20170038.4/1005A/R1/TA

Western Sydney Stadium (Project No 255417) - Stage 2 DA - Response to EPA & DOP

This letter presents a response to queries raised by the NSW Environmental Protection Authority and Department of Planning in letters dated 7 April 2017 and 13 April 2017 respectively.

1.1 EPA COMMENTS – LETTER EF16/2911, DOC152571-01

#### Rock Music Noise

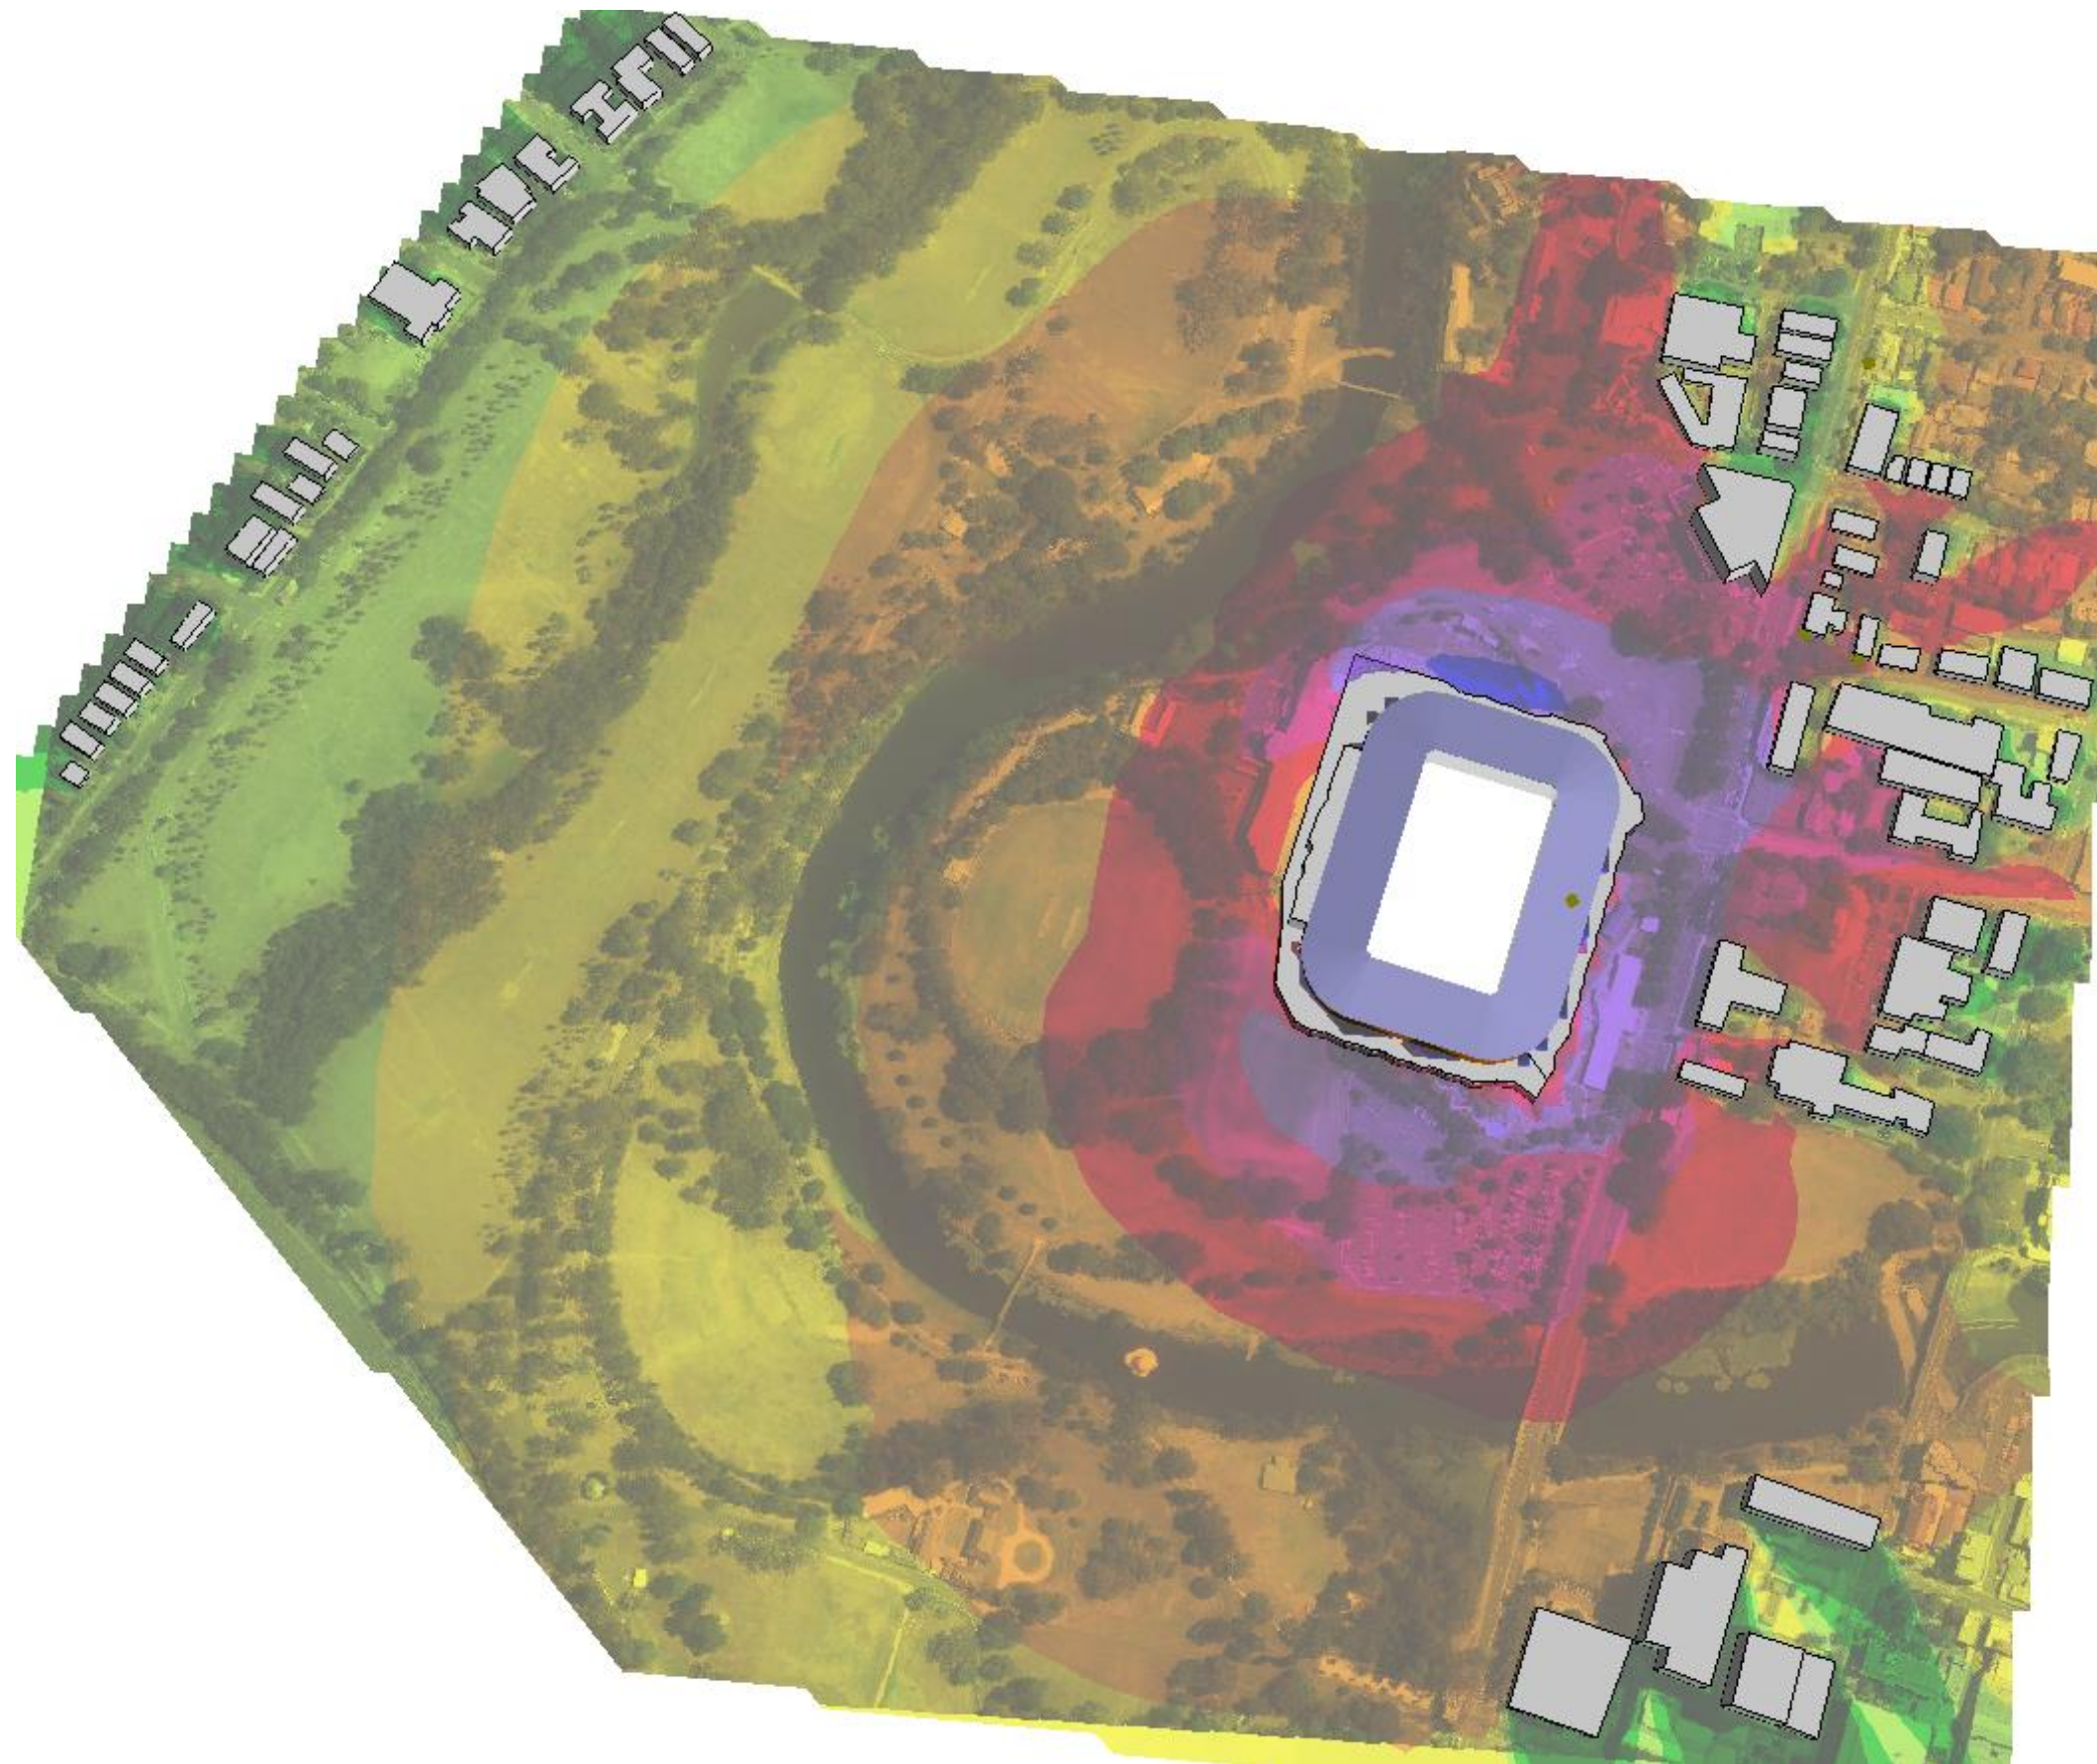
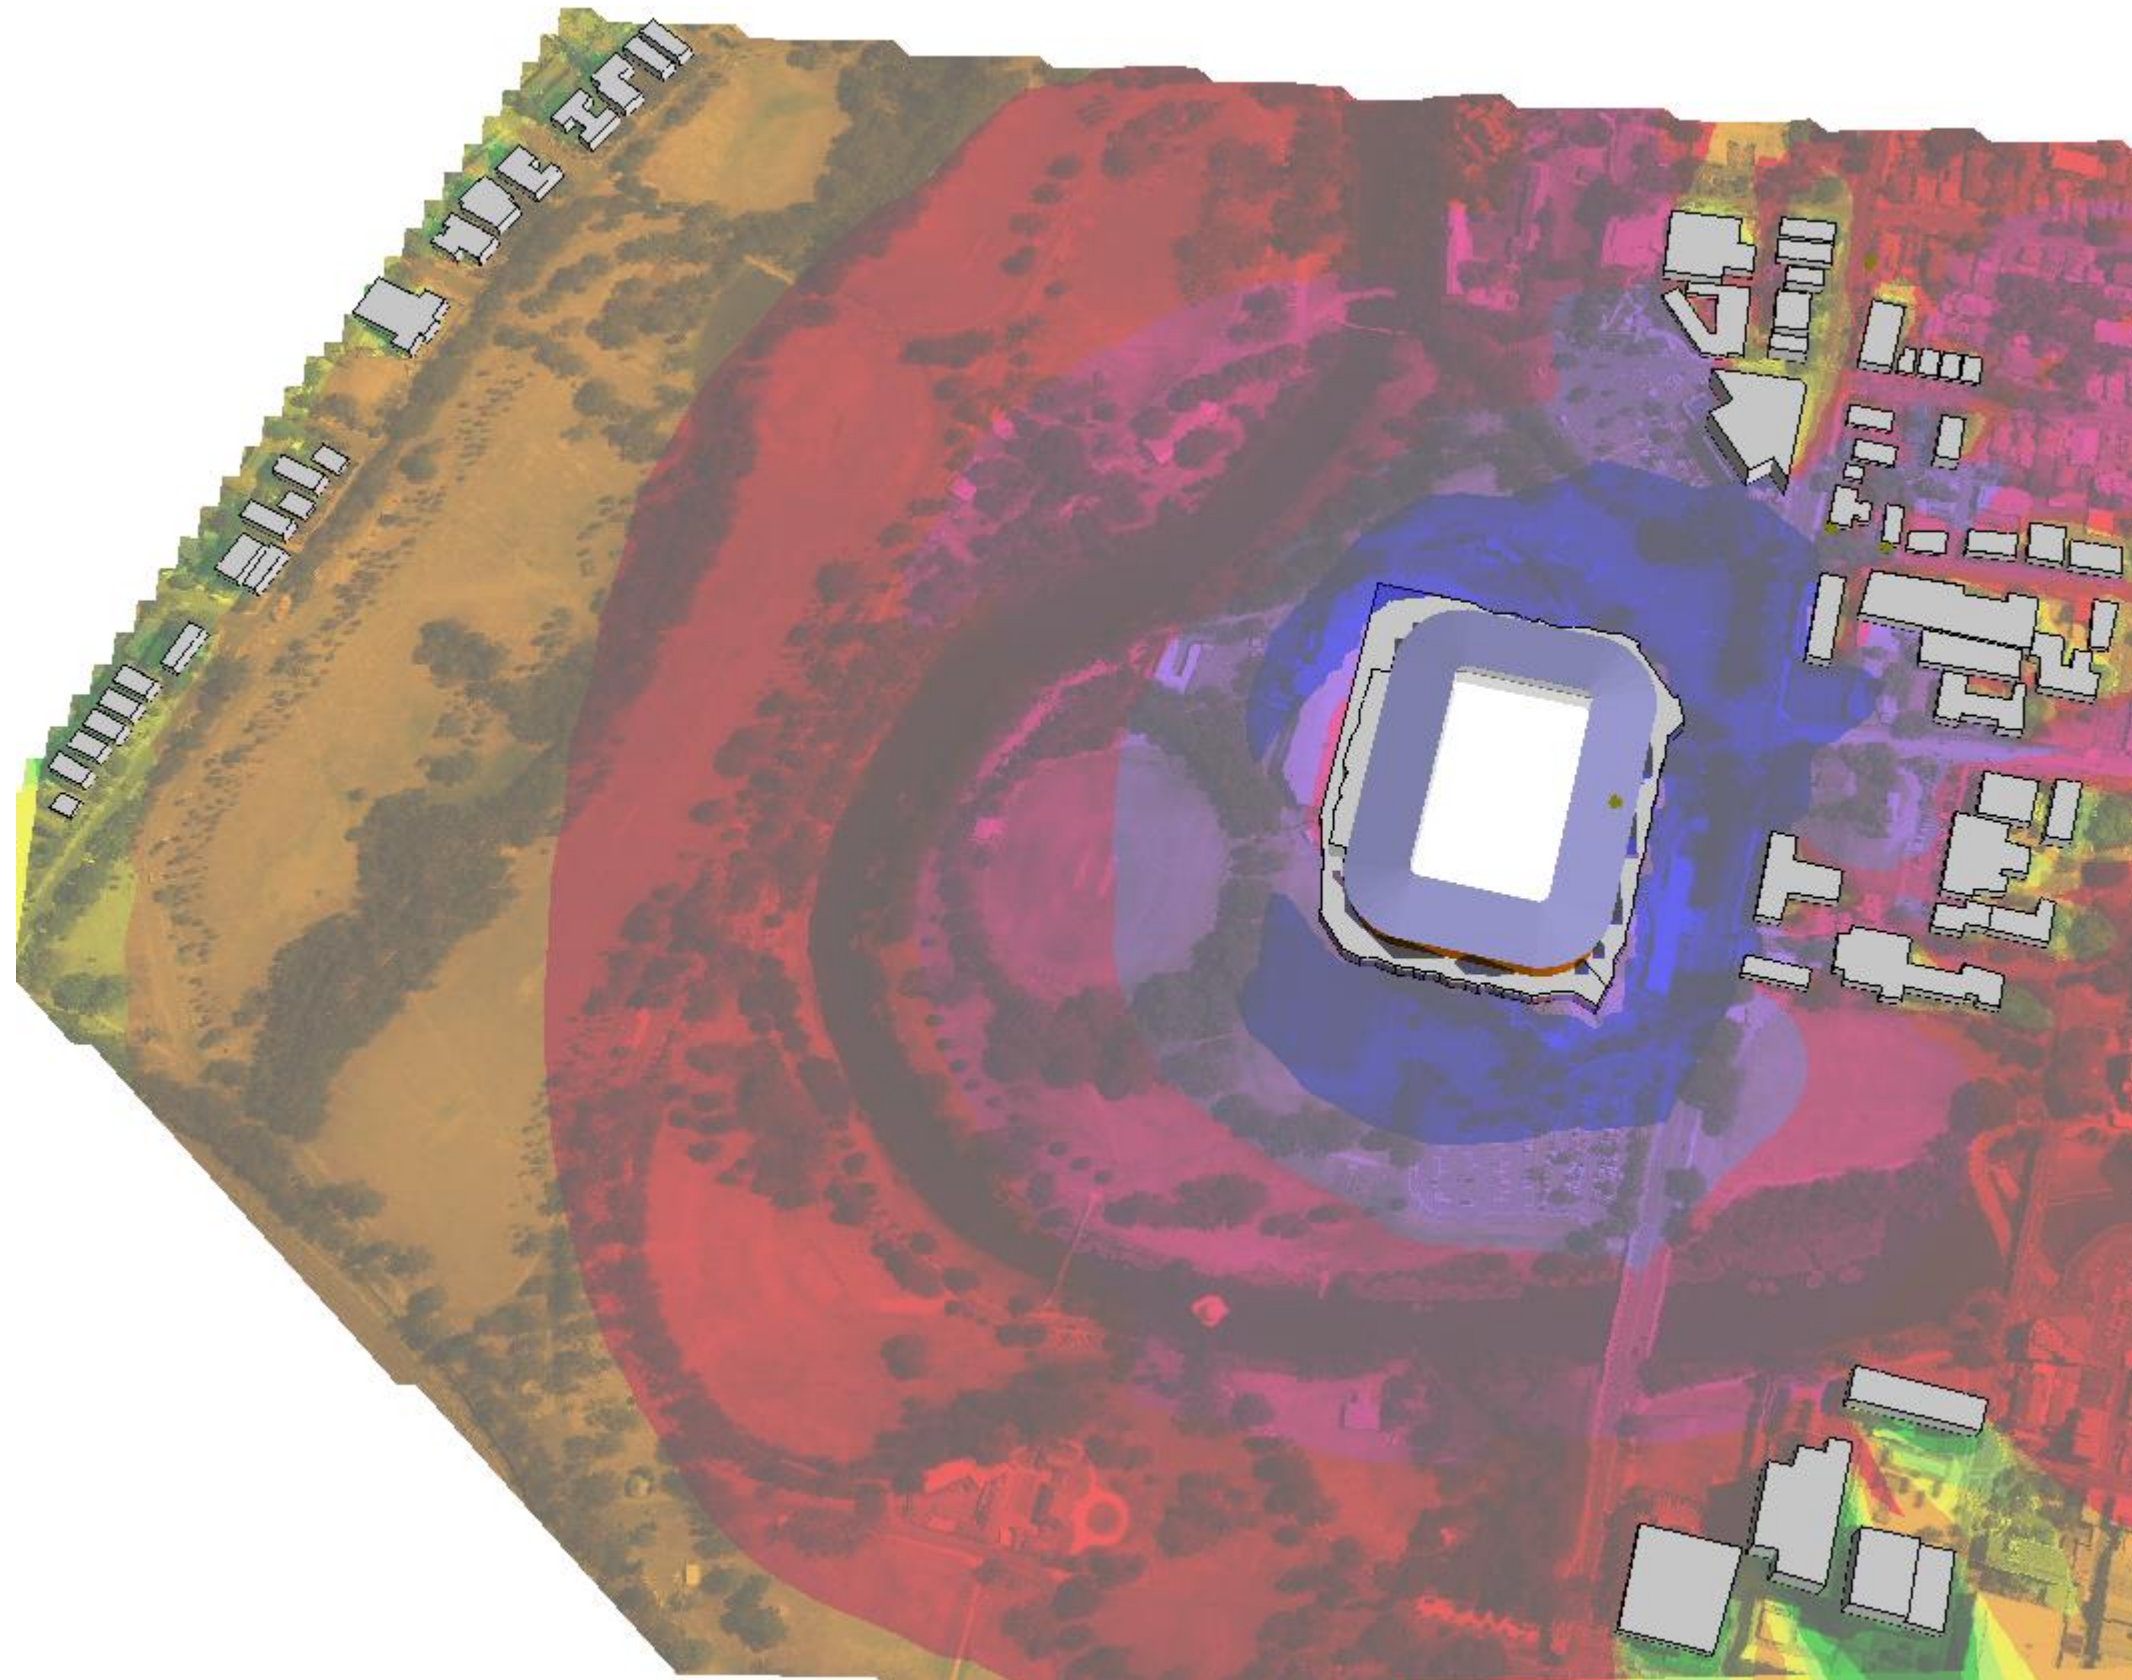
- (a) tabulated data using the various recommended A and C weighted noise descriptors required to facilitate proper evaluation of those predicted noise impacts, and
- (b) details of predicted day-time noise impacts on non-residential noise sensitive land uses, including local schools, the nearby child care facility and the nearby place of public worship (St Patricks Cathedral).

The impacts on all land uses are detailed in the requested "*marked up orthophoto maps showing the predicted noise levels contours for various proposed activities*"

The predicted daytime noise levels for events are the same as the night time events, as ultimate noise levels from concerts, crowds, sporting events, etc are not dictated by the ambient environment.
